Development Control
Ribbles Valley Borough Council

Re: Planning Application 21/0076

Address: Queen Mary Terrace and Bridge Terrace Mitton Road Whalley BB7 9JS

Description: Proposed demolition of 34 existing dwellings and the erection of 50 new dwellings with vehicular accesses, landscaping and other associated works.

Mitton Road, Whalley

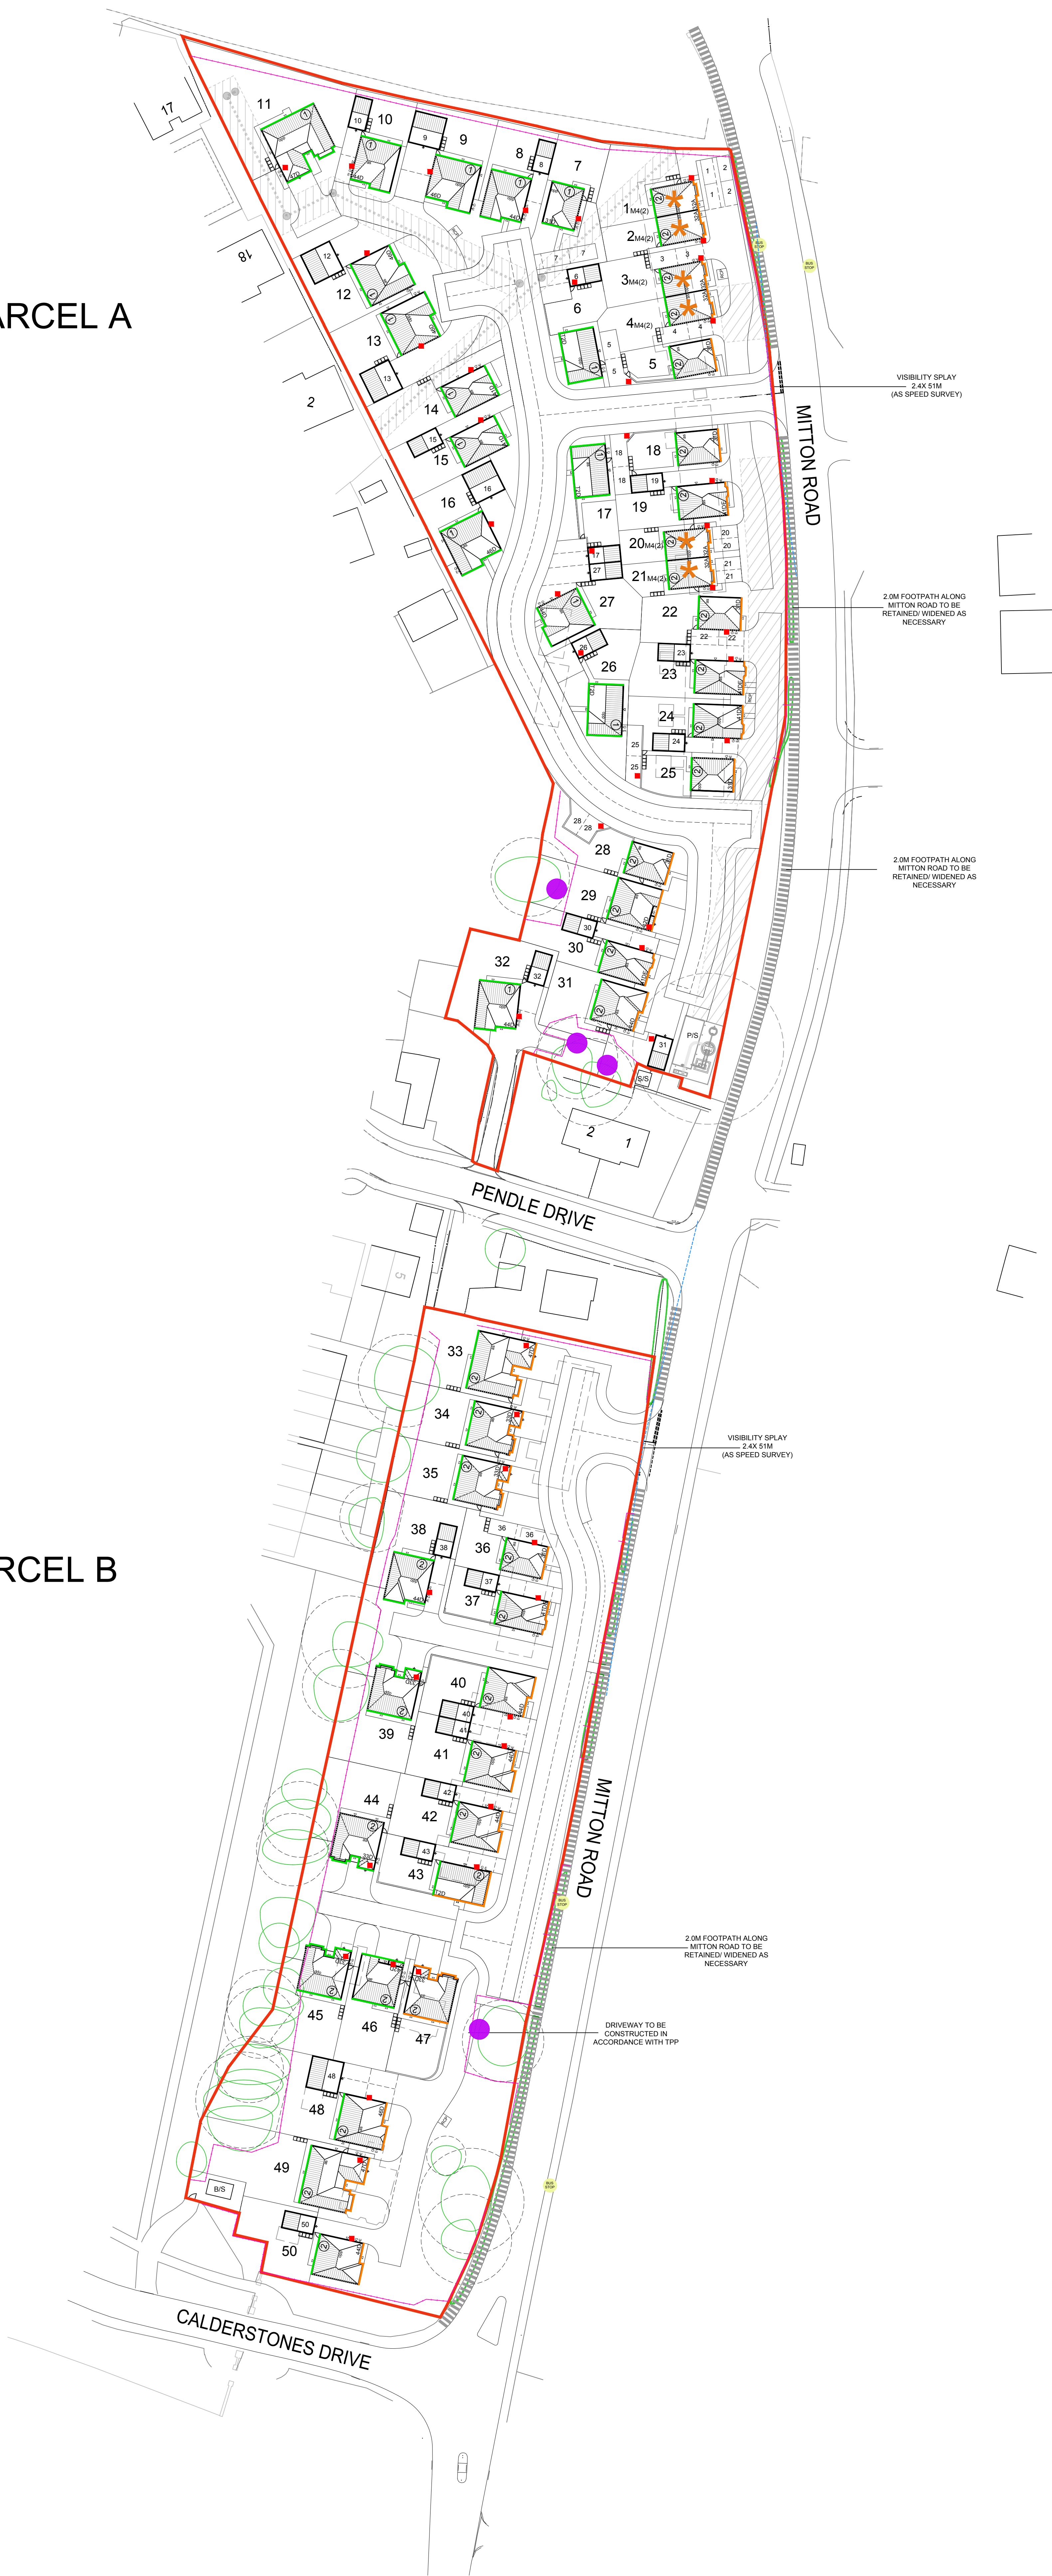
- The proposed visibility splays are 2.4m x 43m which is in accordance with Manual for Streets this is applicable for a 30mph speed limit. However the transport statement indicated that the 85 percentiles speed are 38 mph the visibility splays at all proposed access points should therefore be in excess of 2.4m x 59m. An LCC traffic count taken on the 24th – 31st May 2017 which give 85th percentile speeds of 42mph northbound and 38mph southbound should also be taken into consideration.

- The Design and Access Statement also states that the road way will be 4.8m wide, Lancashire's Residential Road Design Guide requires a carriageway of this nature to be 5.5m in width with 2m footways to either side

- A footway of 2m is required for the total frontage to Mitton Road widening to 2.4m at the Bell mouth junctions.
- All access from the roundabout at Calderstones Drive to the access for Parcel B will require suitable tactile paving to be laid.

- The access for plots 48-50 is too close to the roundabout with Calderstones Drive. It is not acceptable, an alternative access to these plots will be required.

- Similarly the access points to plots 22-25 and 28-31 are also considered to be too close to the junction with Mitton Road.
- The access to Parcel B is virtually opposite to an existing collection of industrial units, there is a grave concern that this will create a conflict of movements at this slightly staggered junction. Consideration to increasing the separation of these junctions should be made.

- With regards to the dwellings as detailed in Manual for Street all single garages are required to measure 3m x 6m internally and all car parking spaces as driveways should measure 5m in length as a minimum. It would appear that Lancashire's Parking Standards have been met.

Refuse Layout Key

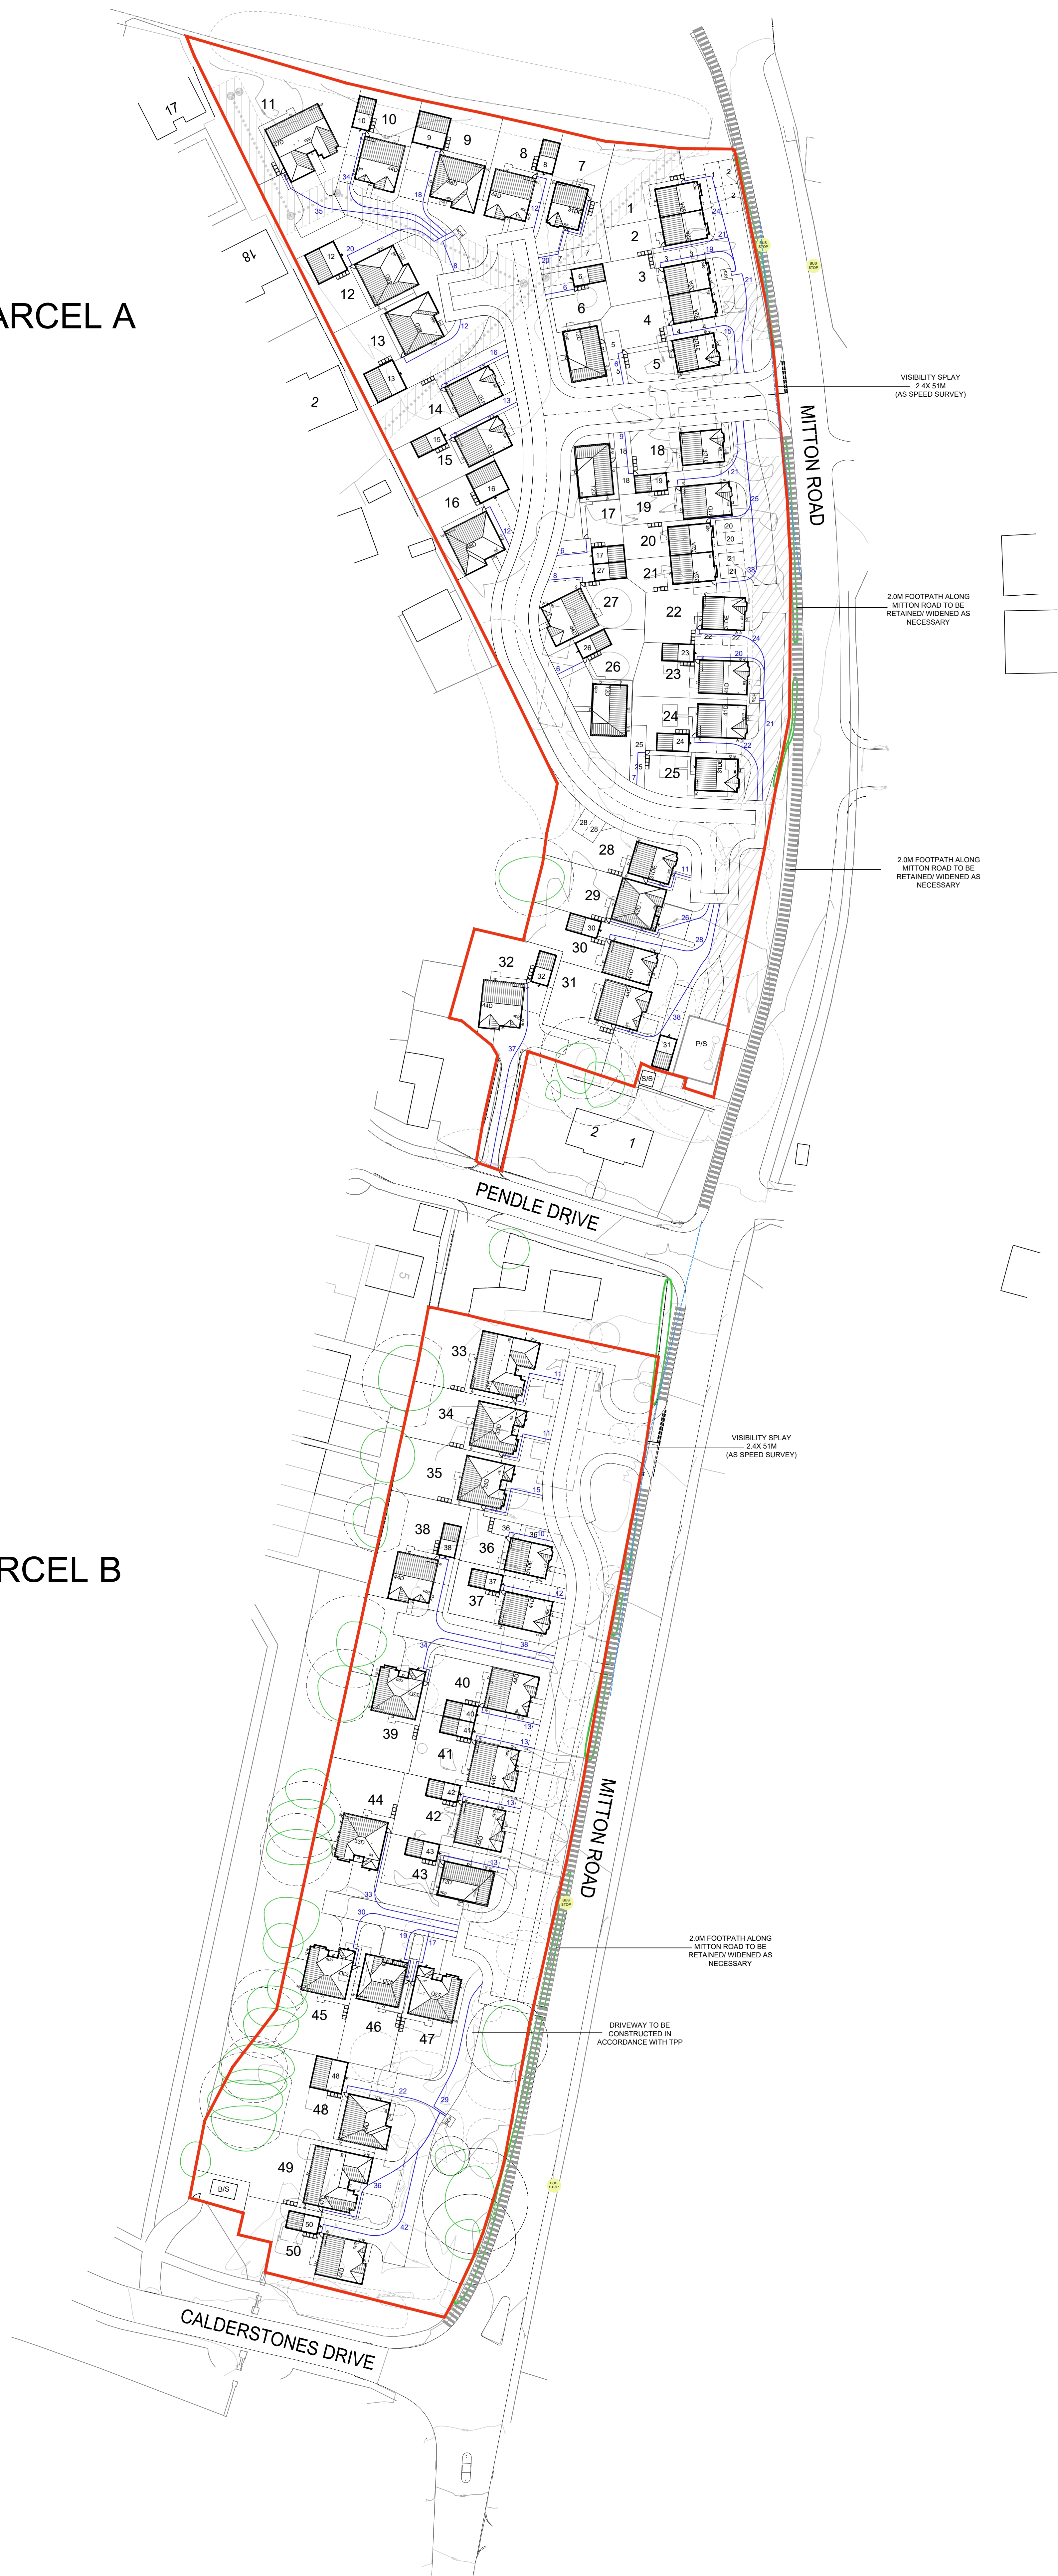
- A swept path analysis for the development should be provided to ensure that the refuse collections vehicles are able to make collections. Care should be taken to ensure that Ribble Valley Borough Council's requirements for refuse and recycling collection are taken into account, rather than South Ribble Borough council's which are referenced in the Design and Access Statement
